**EL PASO COUNTY PLANNING AND
 COMMUNITY DEVELOPMENT
 DEPARTMENT**

**EPC STORMWATER REVIEW COMMENTS
 IN ORANGE BOXES WITH BLACK TEXT**

GRADING AND EROSION CONTROL PLAN CHECKLIST
Retreat at TimberRidge Filing No. 4 (SF-1827)

NO.	REVISION	DATE																													
DESIGNED BY	PRA	SCALE	DATE	1-15-24																											
DRAWN BY	PRA	(H) 1" = 50'	SHEET	3 OF 14																											
CHECKED BY	(V) 1" = N/A	JOB NO.	1185.31

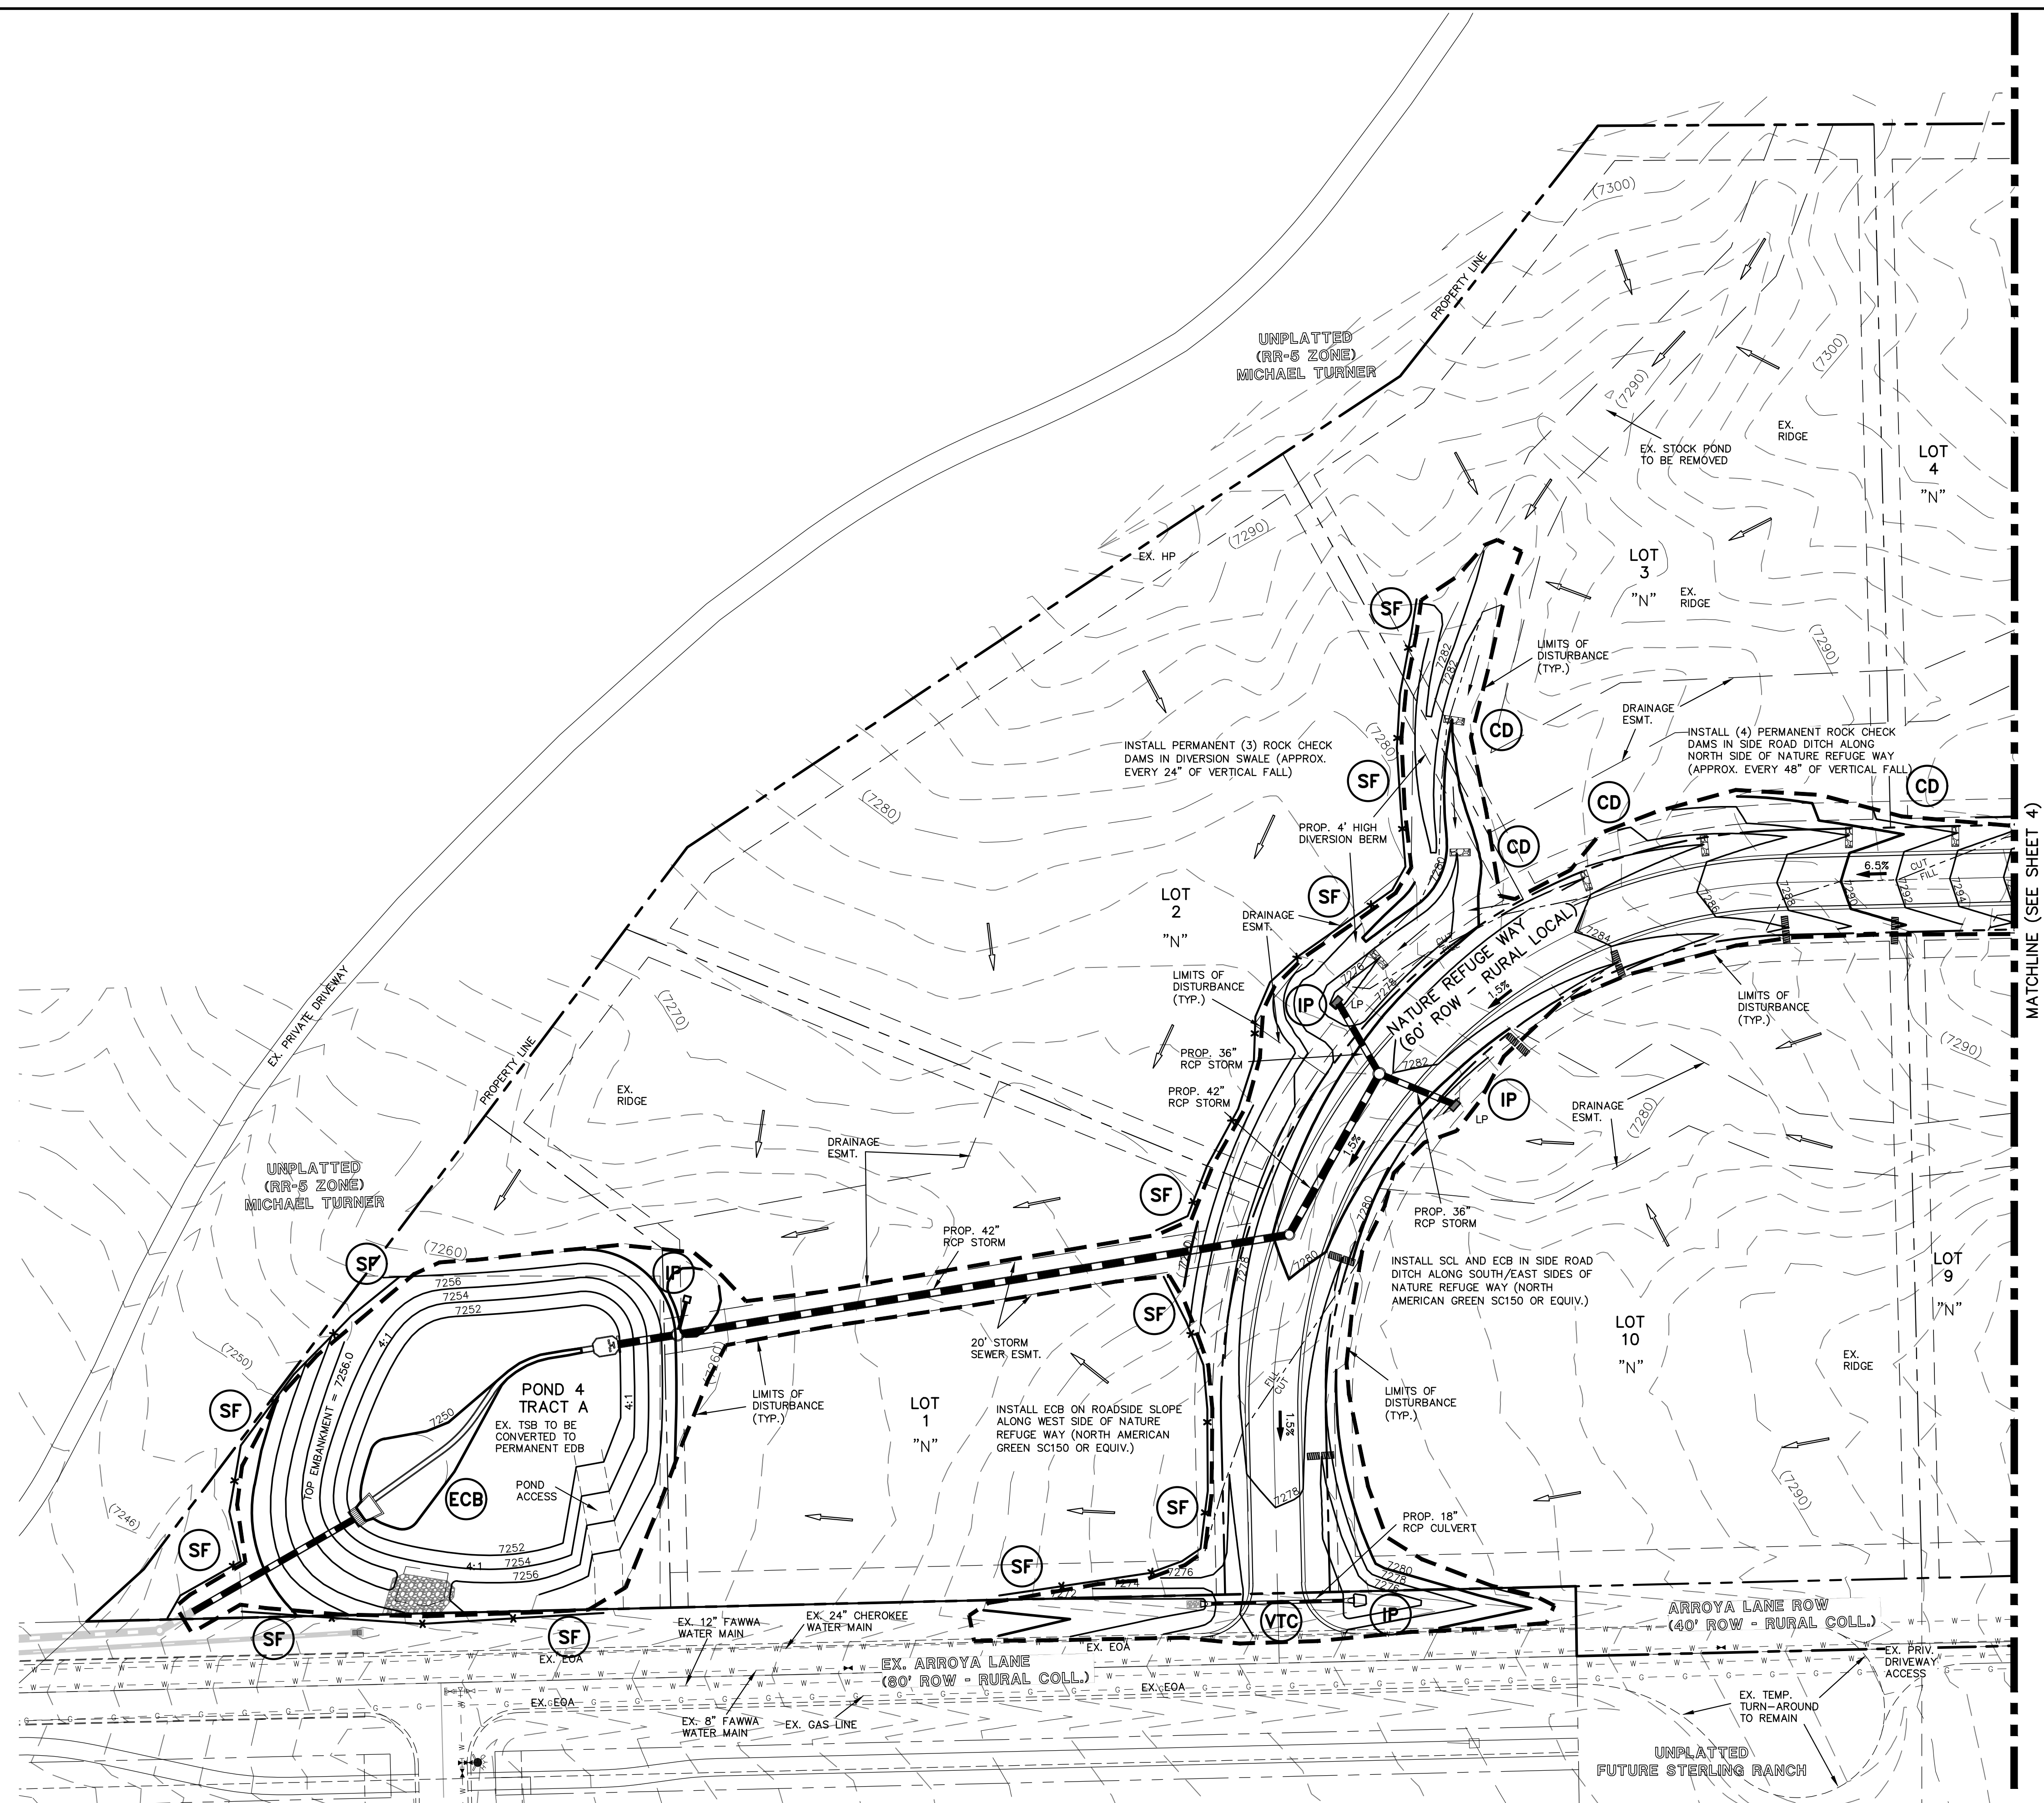
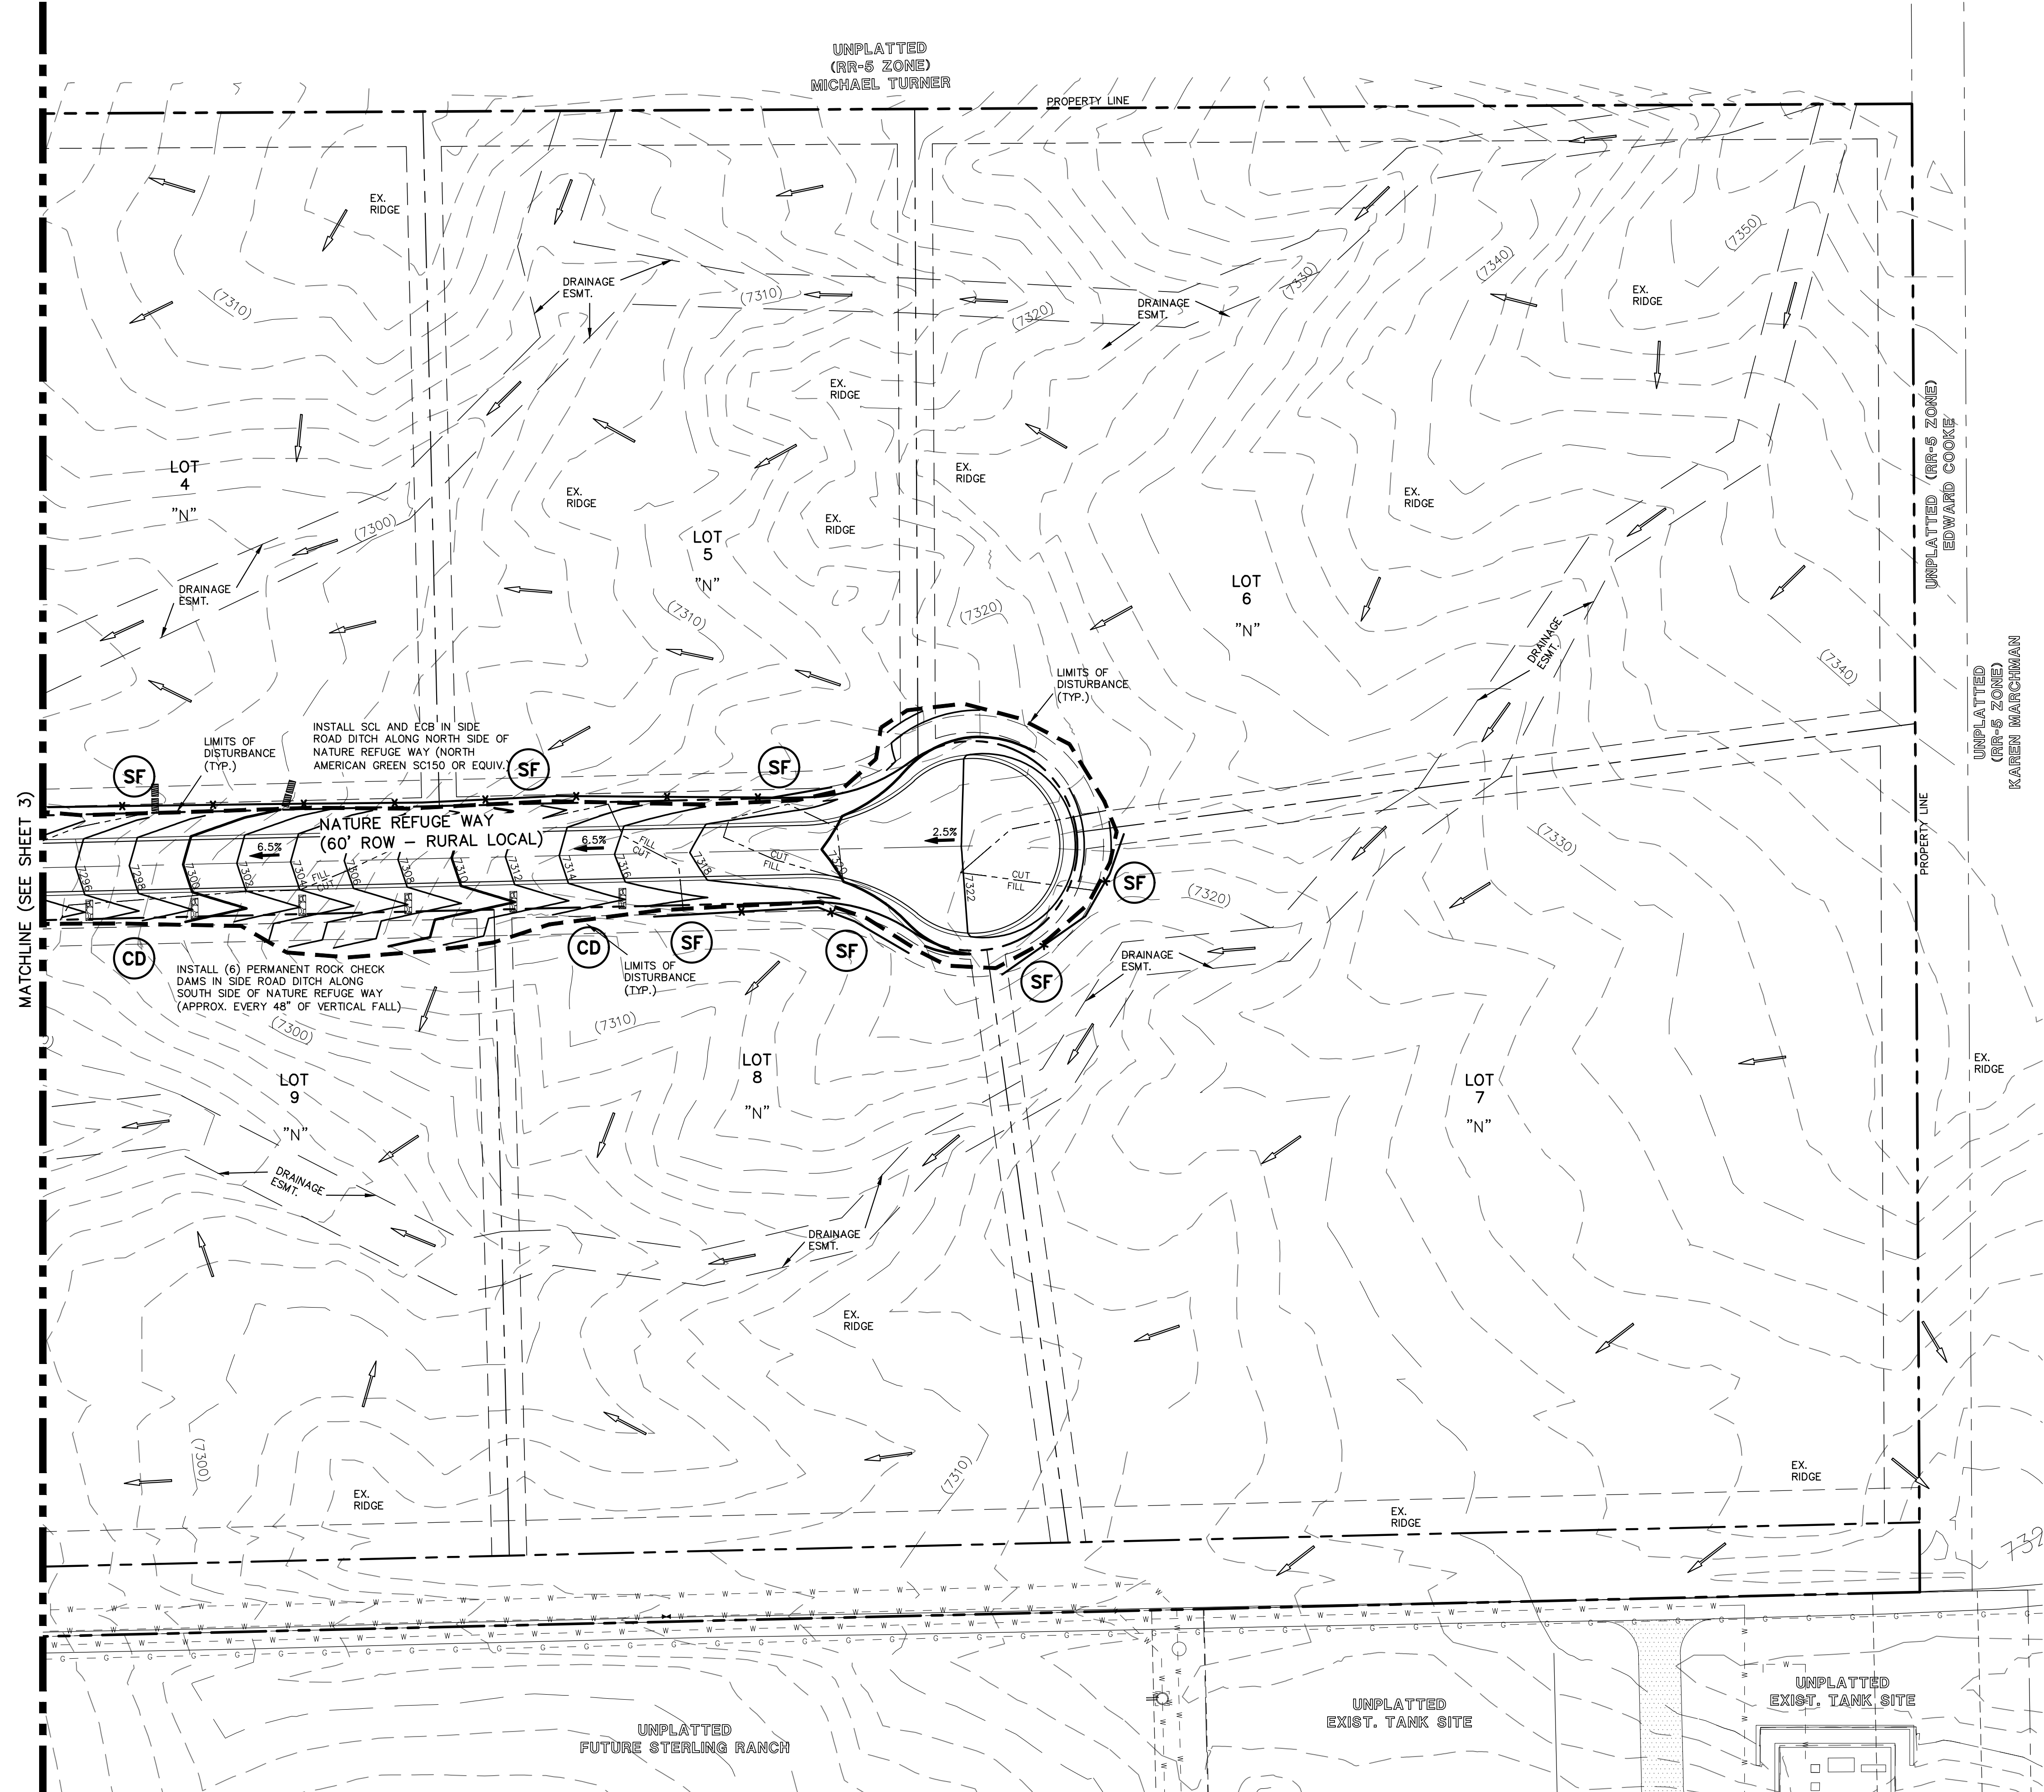
Applicant	PCD
1. GRADING AND EROSION CONTROL PLAN			
a	Vicinity map.	X	Y
b	Adjacent city/town/jurisdictional boundaries, subdivision names, and property parcel numbers labeled.	X	Y
c	North arrow and acceptable scale (1"=20' to 1"=100').	X	Y
d	Legend for all symbols used in the plan.	X	N
e	Existing and proposed property lines. Proposed subdivision boundary for subdivision projects.	X	Y
f	All existing structures.	X	Y
g	All existing utilities.	X	Y
h	Construction site boundaries.	X	Y
i	Existing vegetation (notes are acceptable in cases where there is no notable vegetation, only grasses/weeds, or site has already been stripped).	X	Y
j	FEMA 100-yr floodplain.	N/A	N/A
k	Existing and proposed water courses including springs, streams, wetlands, detention ponds, stormwater quality structures, roadside ditches, irrigation ditches and other water surfaces. Show maintenance of pre-existing vegetation within 50 feet of a receiving water.	X	Y

v	All proposed temporary construction control measures, structural and non-structural. Temporary construction control measures shall be identified by phase of implementation to include "initial," "interim," and "final" or shown on separate phased maps identifying each phase.	X	N
w	Vehicle tracking provided at all construction entrances/exits. Construction fencing, barricades, and/or signage provided at access points not to be used for construction.	X	Y
x	Temporary sediment ponds provided for disturbed drainage areas greater than 1 acre.	X	Y
y	Dewatering operations to include locations of diversion, pump and discharge(s) as anticipated at time of design.	N/A	N/A
z	All proposed temporary construction control measure details. Custom or other jurisdiction's details used must meet or exceed EPC standards.	X	Y
